CITY OF ALBUQUERQUE

December 13, 2022

Re: La Luz Hub TI
1115 Griegos Rd. NW
Traffic Circulation Layout
Architect's Stamp XX-XX-XX (F14-D082)

SHEET TITLE: Fire 1

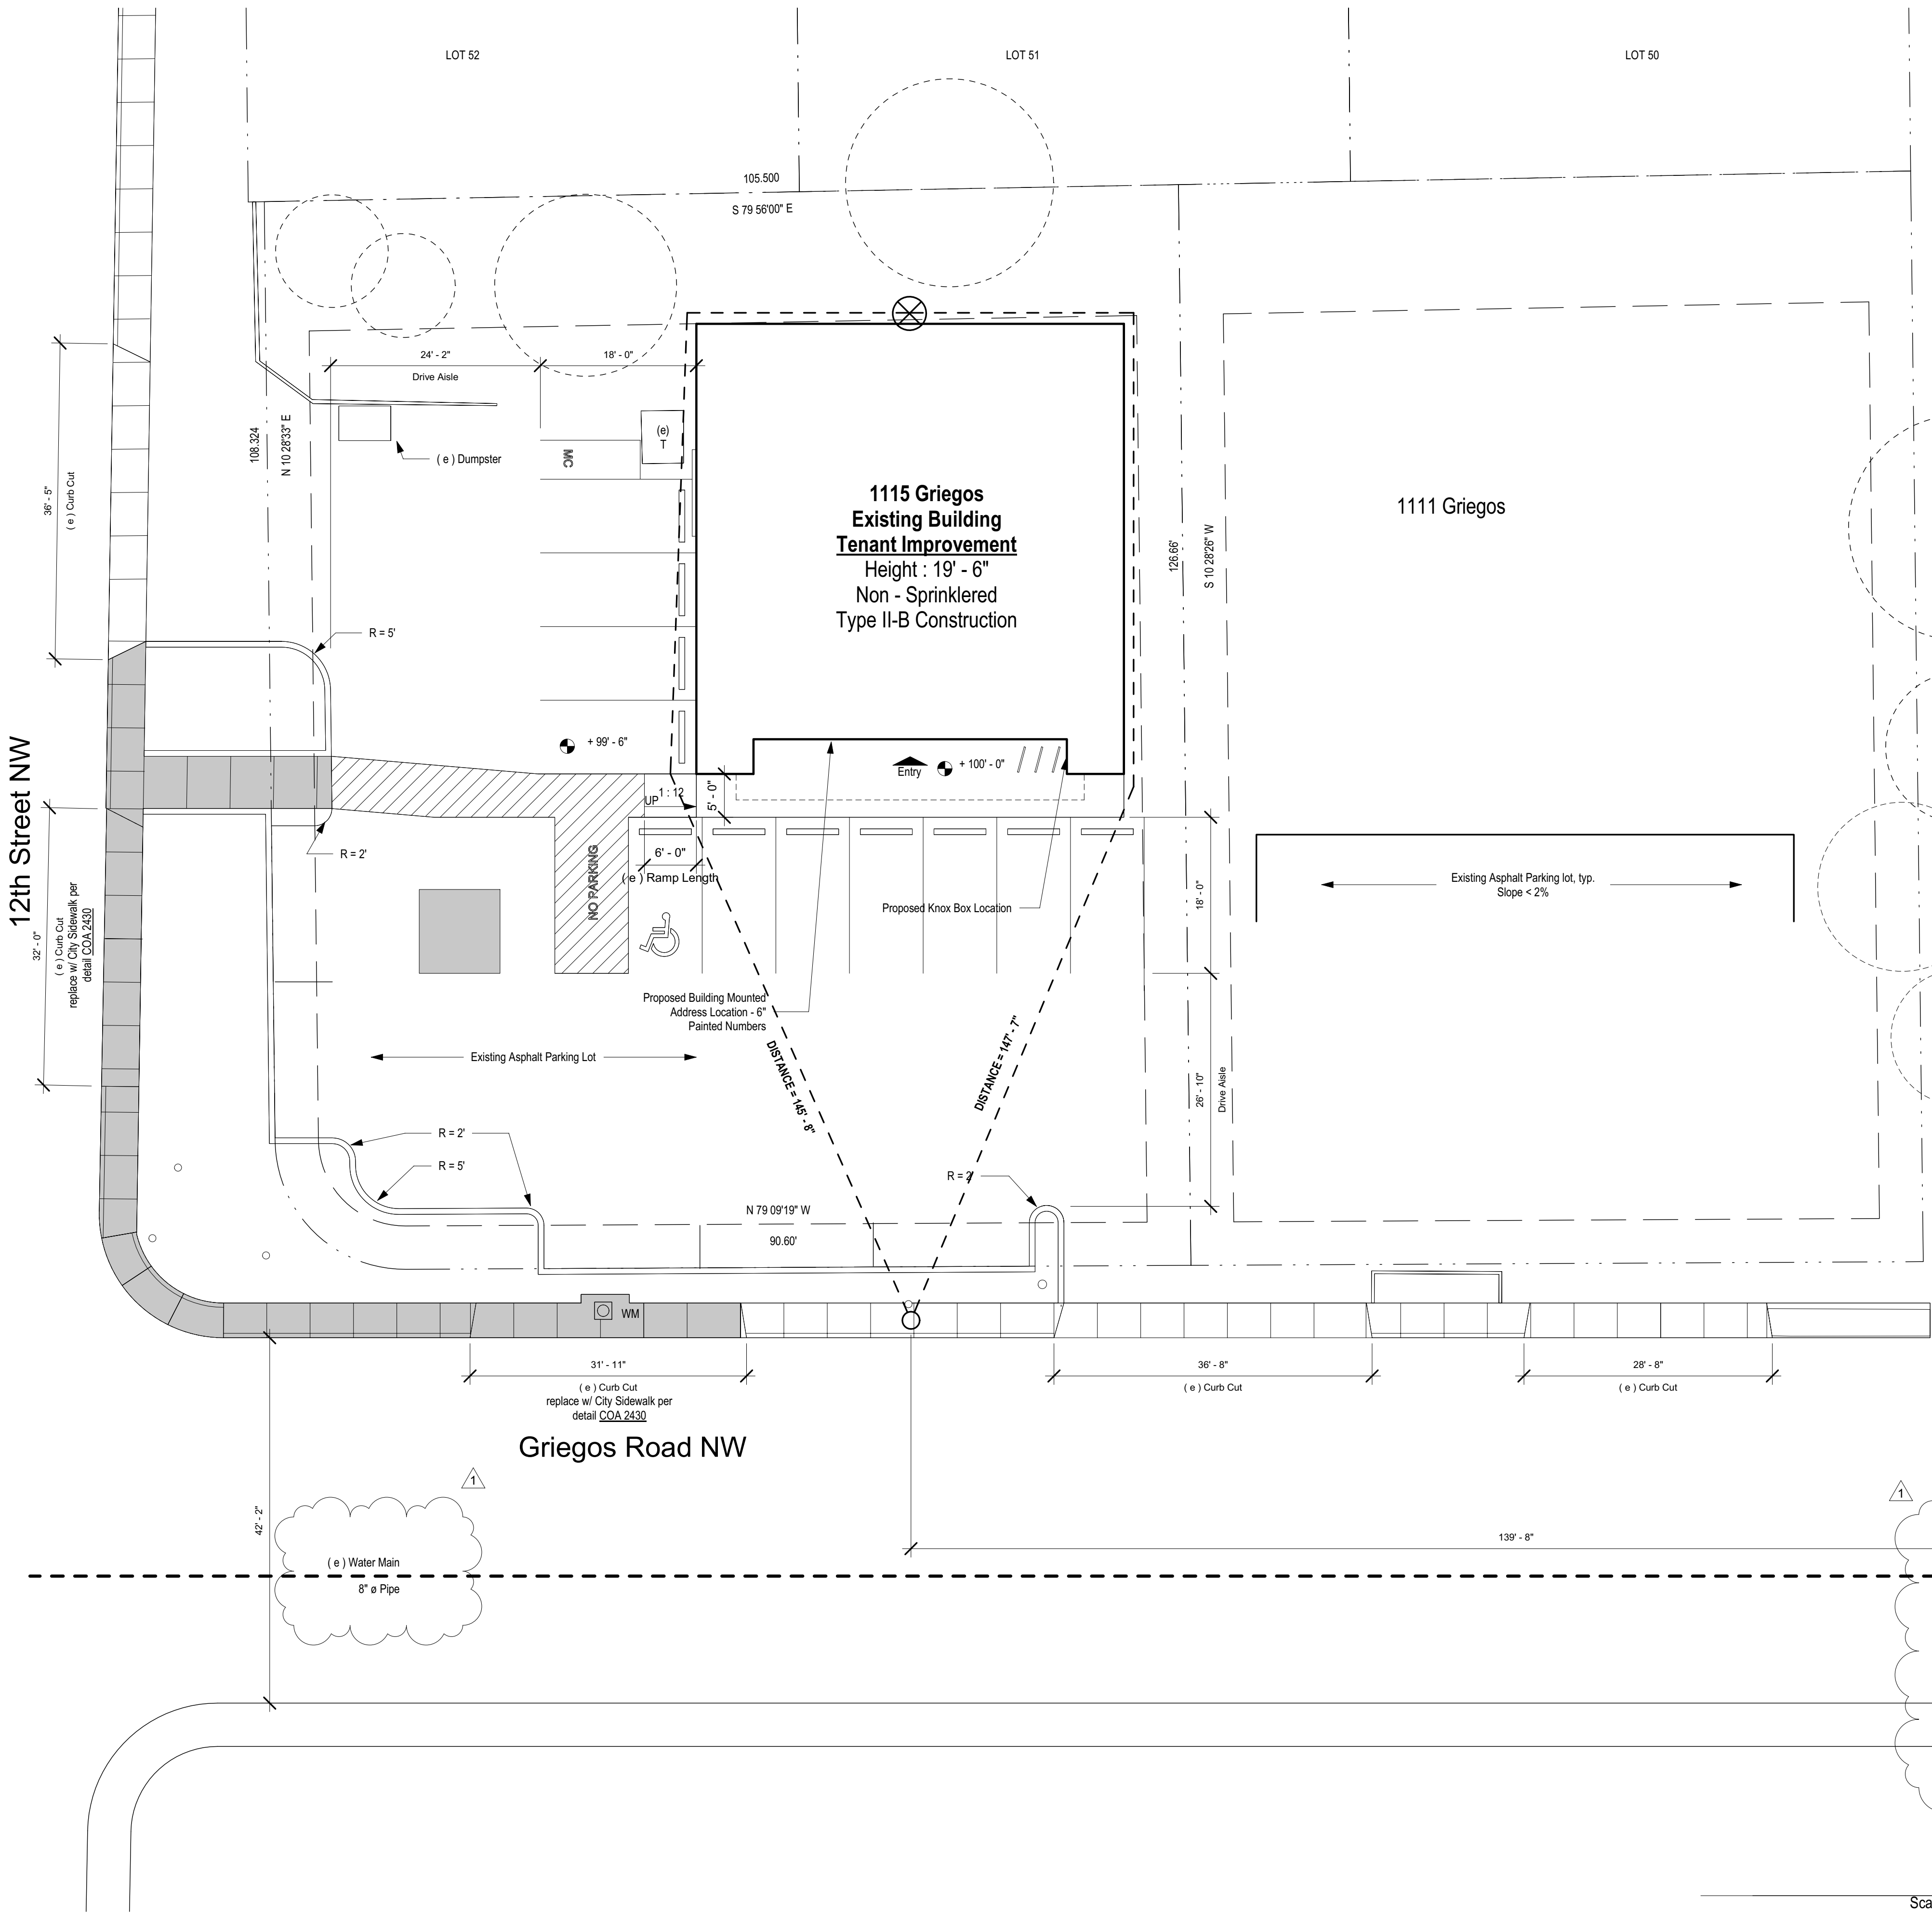
5. Provide details for the interior ADA ramp.
6. Provide a copy of Fire Marshal and Solid Waste approval.
7. The pavement marking "MC" should be shown in the opposite direction for motorcycles entering the parking space.
